24 August, 2012

Your ref: MP06\_0228 MOD.3

**RE: FURTHER RESPONSE TO SUBMISSION REPORT  
SHOALHAVEN STARCHES EXPANSION PROJECT  
PROPOSED RELOCATION OF APPROVED STAFF CAR PARK  
PROJECT APPROVAL MP06\_0228.MOD 3**

PLAN SHOWING PROPOSED TRAFFIC ARRANGEMENTS  
REDUCTION RATION 1:500

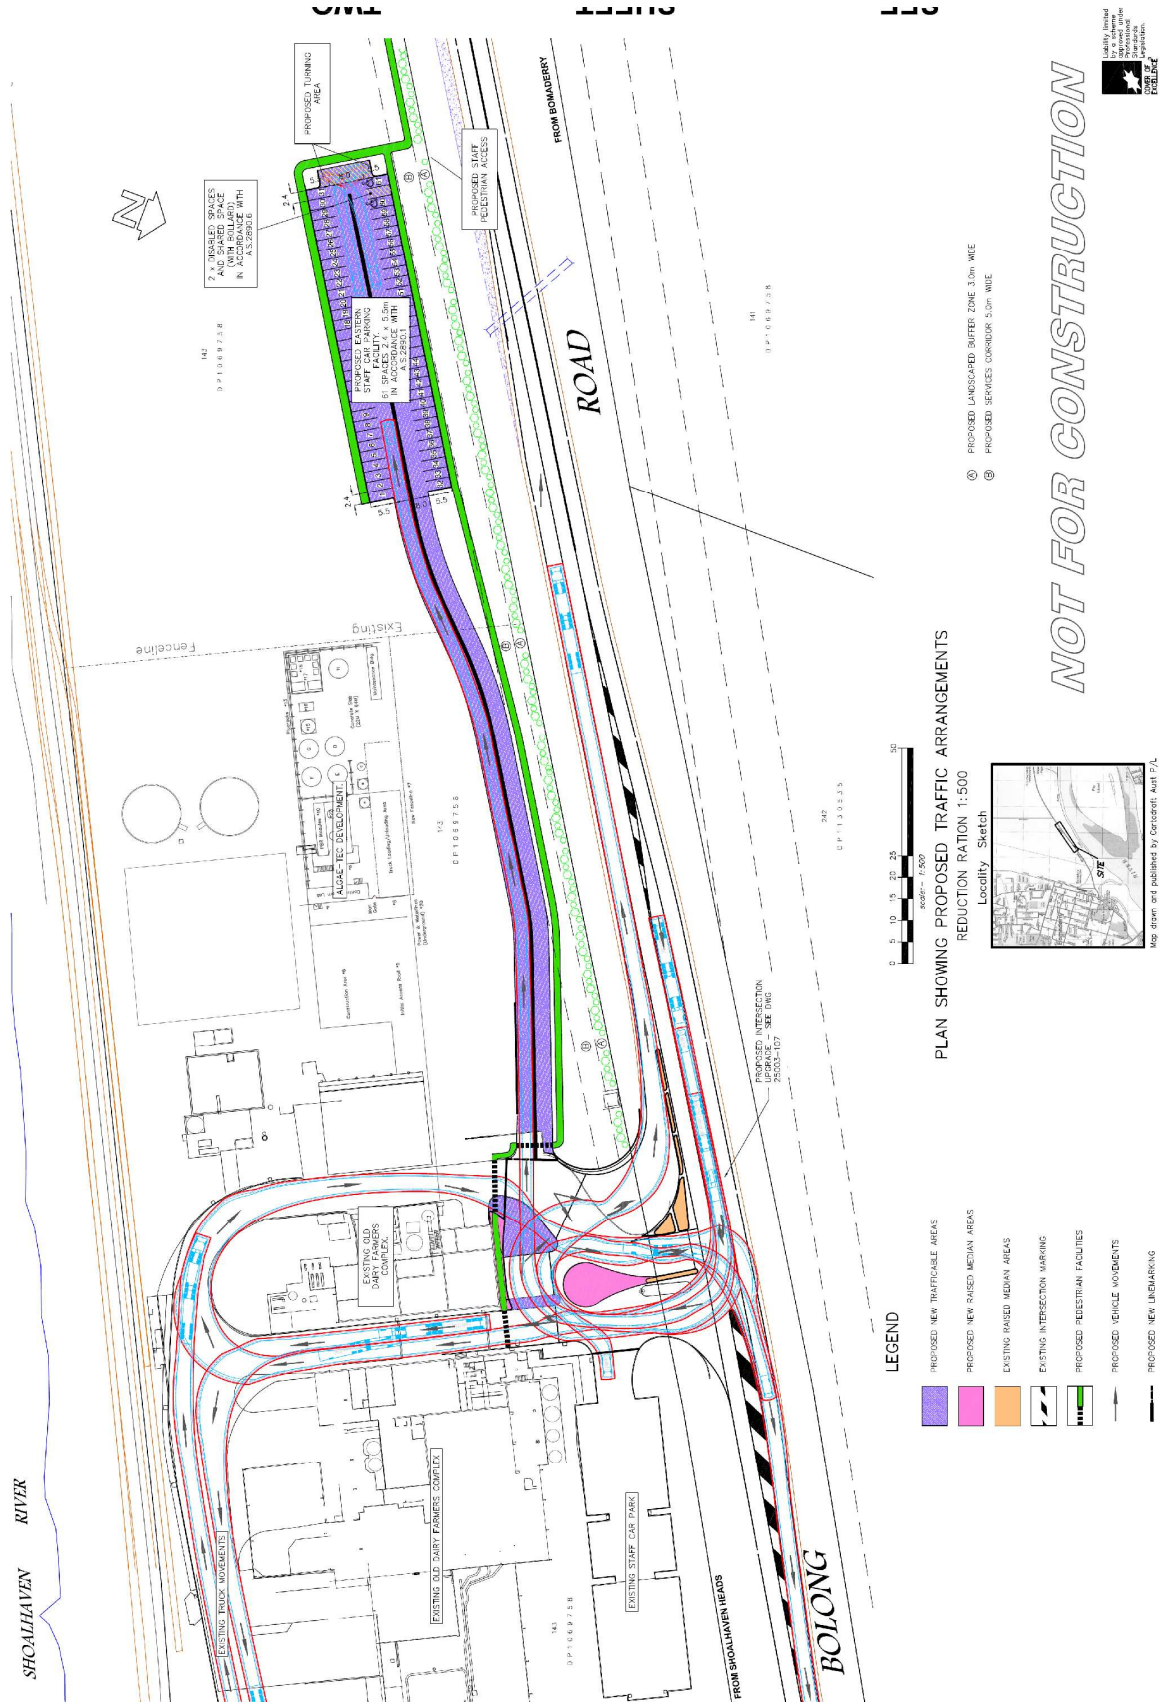
<p><i>Make same revisions to PPLA Figures in Annexure 3 of EA. Note DWG. L01 in Annex 3 shows a different design for the car park, without turning area at western end. Please correct.</i></p>	<p><b>Annexure 2</b> includes revised landscape plans incorporating the correct car park design.</p>
<p><i>Amend Figure in Attachment 2 of RTS to show approved car parking in pink shading as referenced in the text on page 2. Also show on this figure the 12 spaces required by the Interim Packing Plant approval. Confirm if these have been constructed.</i></p>	<p>The plan included in Attachment 2 does outline the original 60 spaces approved in the Project Approval in pink within the original Response to Submission Report. However, whilst this plan shows the original approved layout of these spaces; it has come to our firm's attention that the Master Traffic Plan approved both by Council and the RMS shows these 60 parking spaces located further to the west of the site.</p> <p>As a result a further plan has been prepared which reveals the final approved location of these parking spaces. In addition this plan shows the proposed modified location of these spaces (<b>Annexure 3</b>).</p> <p>This plan also shows the location of the 12 spaces that are required to be provided in association with the approved Interim Packing Plant as approved by Shoalhaven City Council (RA 11/1002). At this point in time, whilst works have commenced in relation to this project, the project has not been finalised, including the provision of these additional parking spaces.</p>

<b>Issues raised by SCC</b>	<b>Shoalhaven Starches Responses</b>
<p><b>The new staff car park</b></p> <p><i>The proponent has indicated the car park will be designed to comply with AS2890 in all respects and this is supported. Appropriate line marking and internal signage should be installed to mitigate conflicts between cars and trucks using the common access and manoeuvring areas.</i></p> <p><i>Car parking spaces are proposed to be the very minimum width under Australian Standards, although the aisle width proposed is considerably wider presumably to compensate for this. Further, we note the ARC traffic study recommends provision of a suitable turnaround area at the western end of the car park which is supported. Provision should be made for at least 2 spaces that meet the additional requirements for people with a disability.</i></p> <p><i>Accordingly modification approval should be conditioned as follows:</i></p> <p><b><i>“A suitable turnaround facility is to be provided at the western end of the car park to facilitate safe efficient turnaround for those vehicles that could not find a car park”; and</i></b></p> <p><b><i>“Applicant is to consider providing an overflow car parking area (gravel all weather surface) at the western end of the car park to accommodate overflow car parking on site.”</i></b></p> <p><i>Council requests the submission of detailed plans for approval.</i></p>	<p>The attached plans held in <b>Annexure 1</b> include a revised parking layout showing a suitable manoeuvring area at the western end of the car park (as shown in plans submitted with original proposal); as well as disabled parking spaces.</p> <p>Shoalhaven Starches commit to this requirement, refer plans included in <b>Annexure 1</b>.</p> <p>Shoalhaven Starches <u>objects</u> to this requirement. Project Approval MP06_0228 requires the provision of 60 spaces to be provided to southern side of Bolong Road. This Modification Application seeks to in effect comply with this requirement. Council’s submission provides no justification for the provision of <u>additional</u> ‘overflow’ car parking. It should be noted that with the closure of one of the driveways to the ‘Moorehouse’ site as required by Council an additional 4 spaces were able to be provided in this car park. In addition the proposed modified car park provides 61 spaces rather than the required 60 spaces. The overall development will therefore provide more on-site parking than that originally required by the Project Approval. Under these circumstances Shoalhaven Starches objects to the imposition of this draft condition.</p>
